Your Ref: 100343322-001
Our Ref: 20/03261/LBC

Application No: 20/03261/LBC
Proposal: Listed Building Consent for installation of soil pipe on front elevation of building
Address: 59 High Street Crail Anstruther Fife KY10 3RA

proposed elevations 5410-1.100.04B  
1:100 @ A4

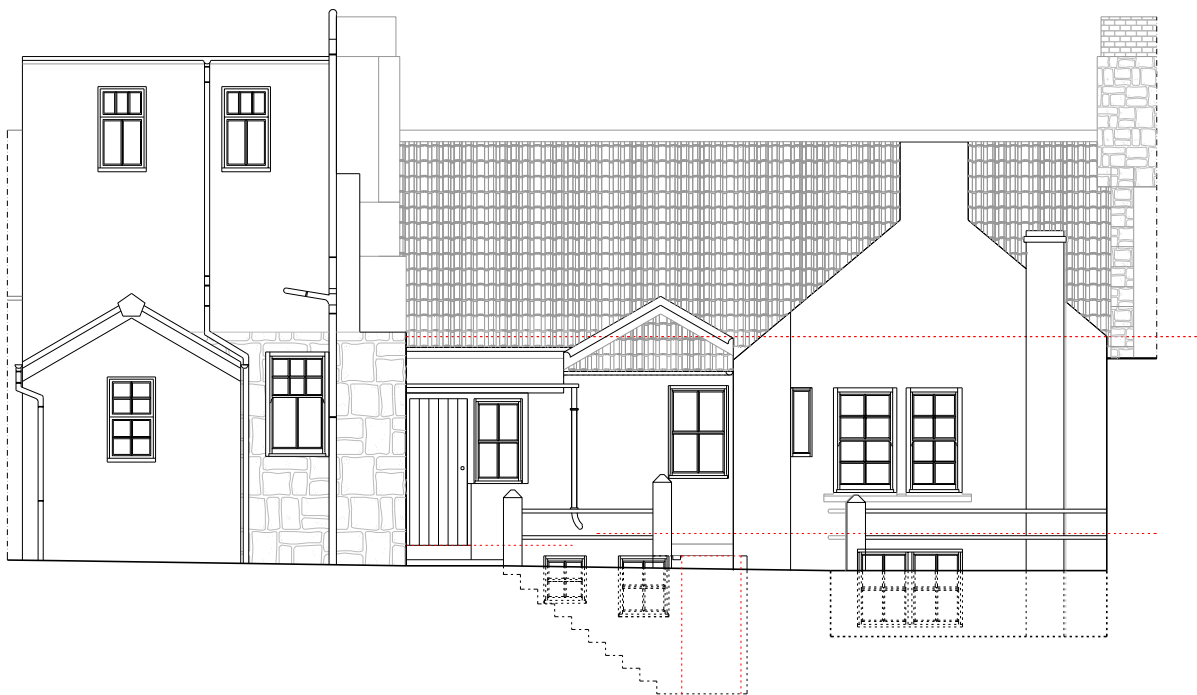
1. You have not submitted existing elevations to a scale of not less than 1:100 so we can identify the existing.
2. The proposed floor plan would seem to suggest that you are removing internal walls of a listed building. Please confirm.
3. Please clearly identify the proposed works on the proposed elevations
